November 29, 2018

RE: **Sunset Gardens Apartments**
86th and Sunset Gardens SW
Grading Plan Stamp Date: 11/25/18
Drainage Report Stamp Date: 11/25/18
Hydrology File: L10D032

Based on the submittal received on 11/26/18, the Grading Plan and Drainage Report are approved for Site Plan for Building Permit.

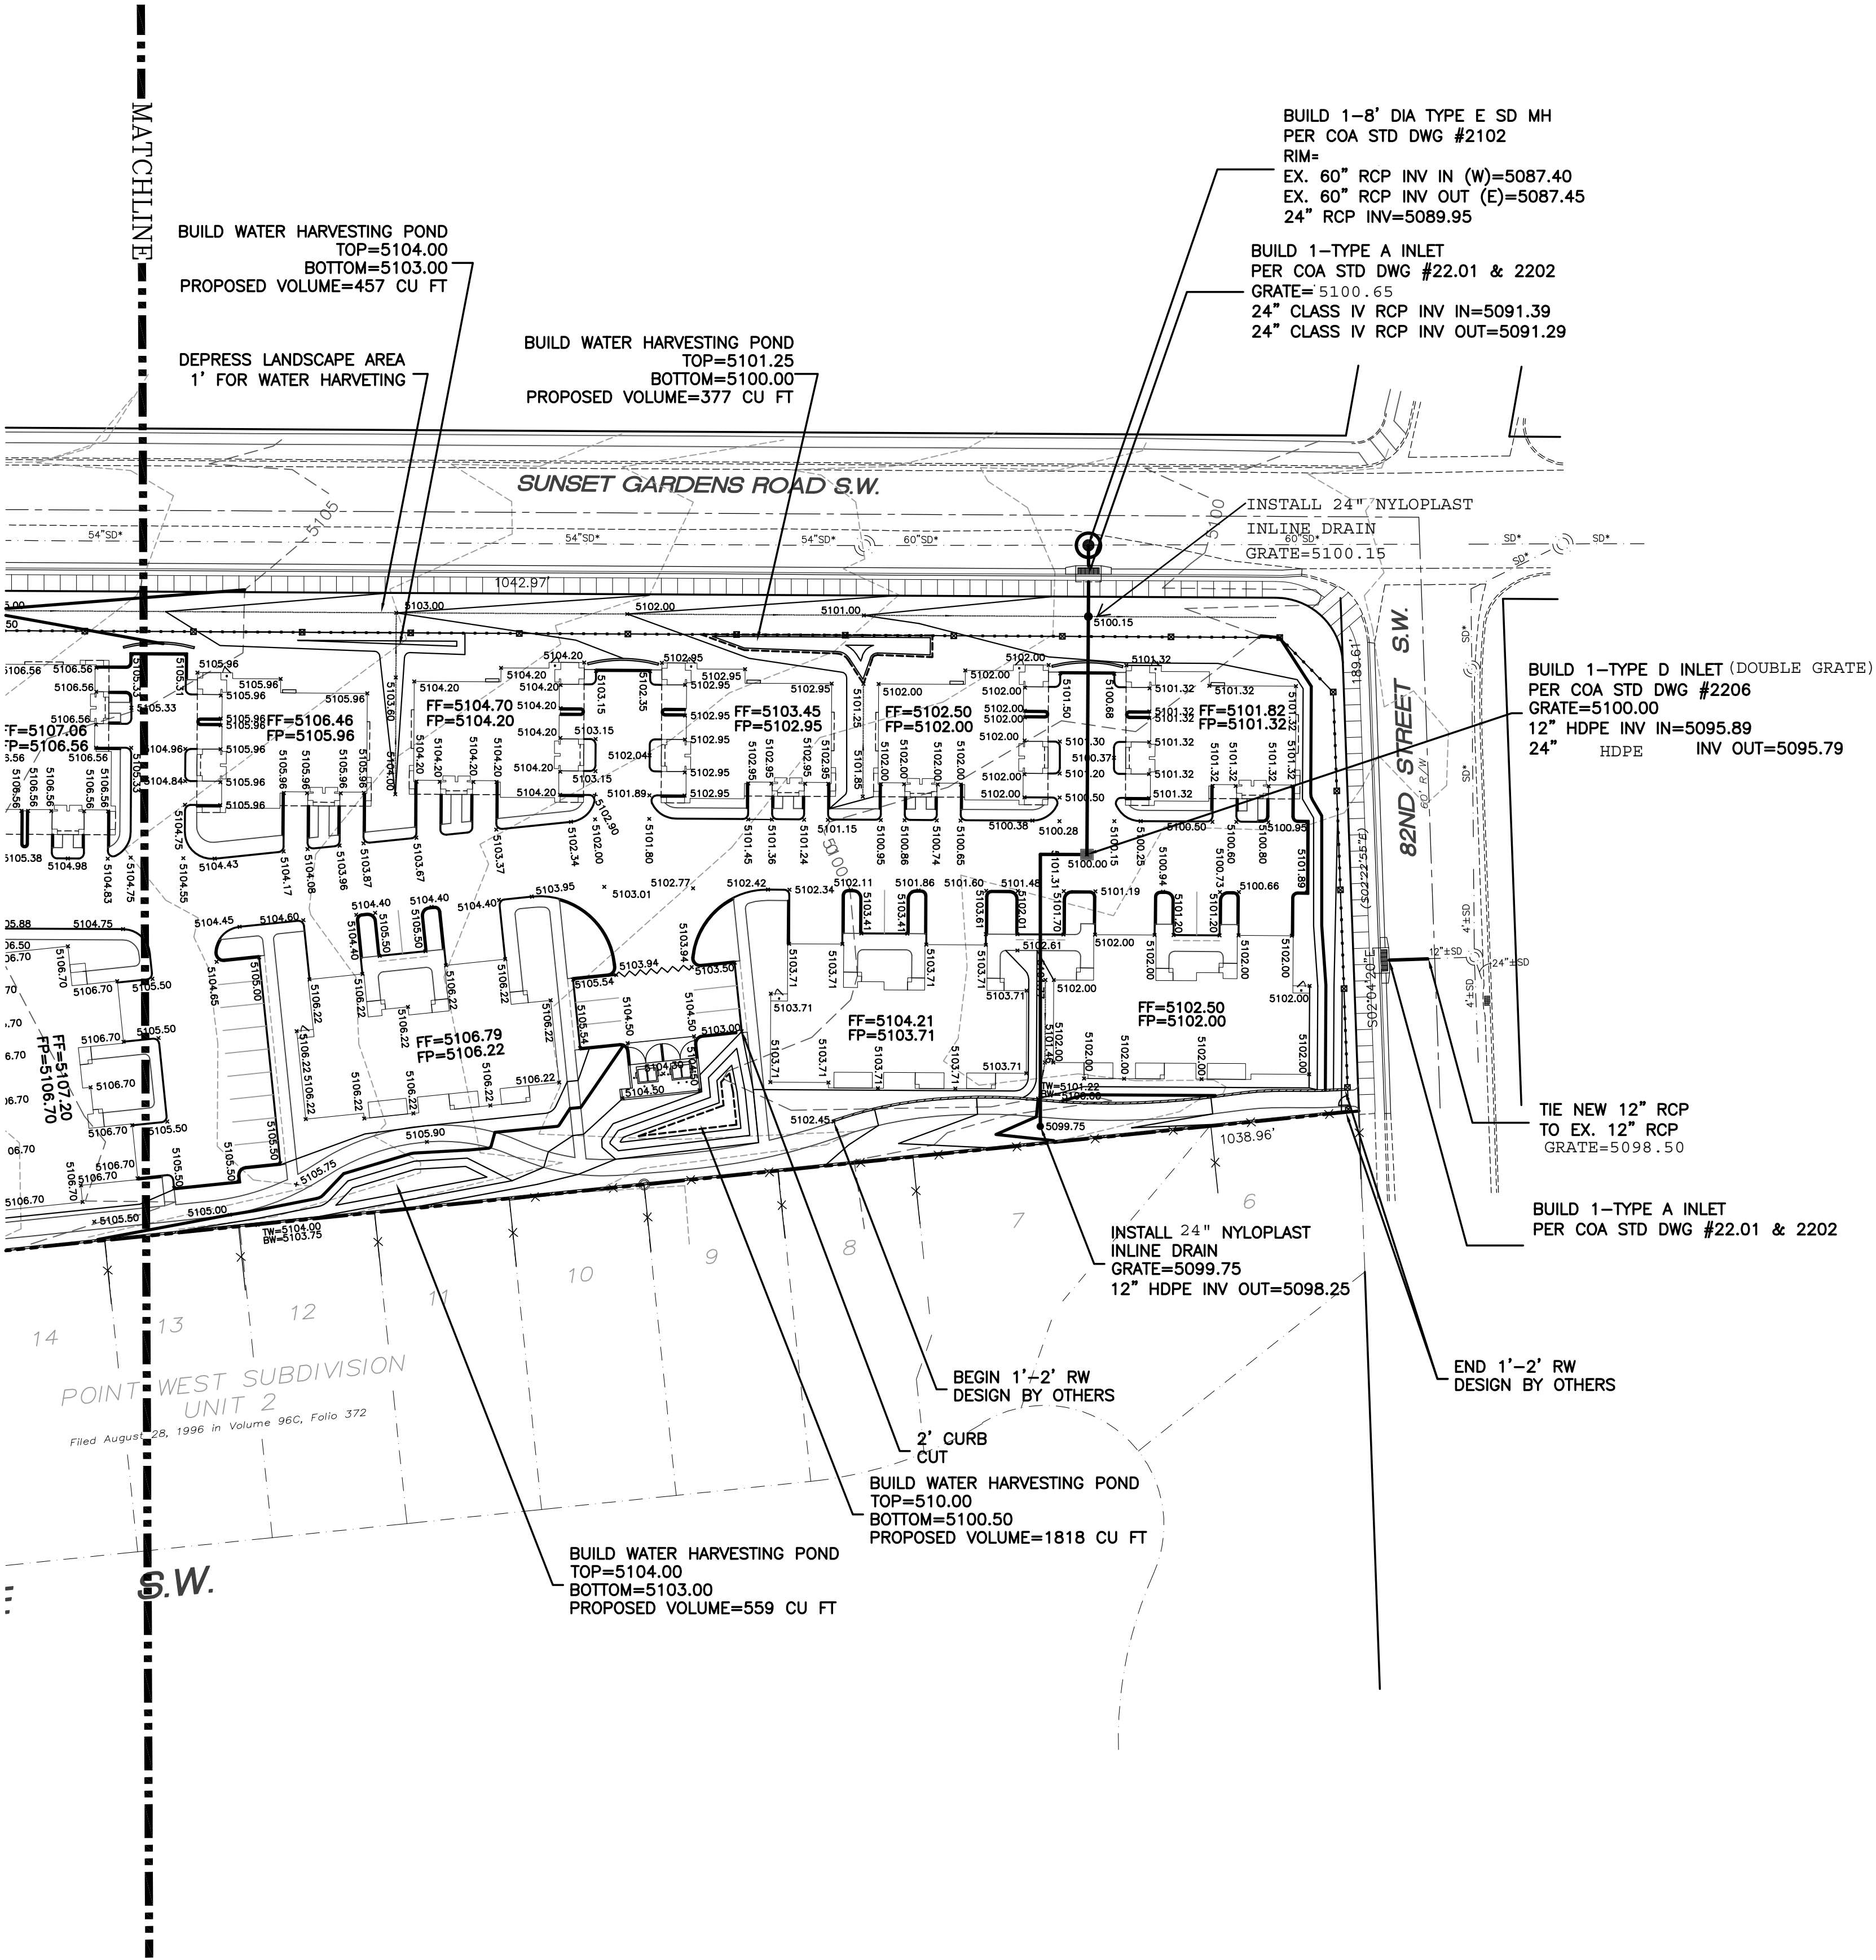
3. Provide sumps around the nyloplast inlets (Basin A & C) to generate the head required in Appendix C (Hydraulics).
4. Pipe capacity and profiles for public and private storm drain, calculated along the EGL, will be required prior to building permit or work order, whichever comes first.
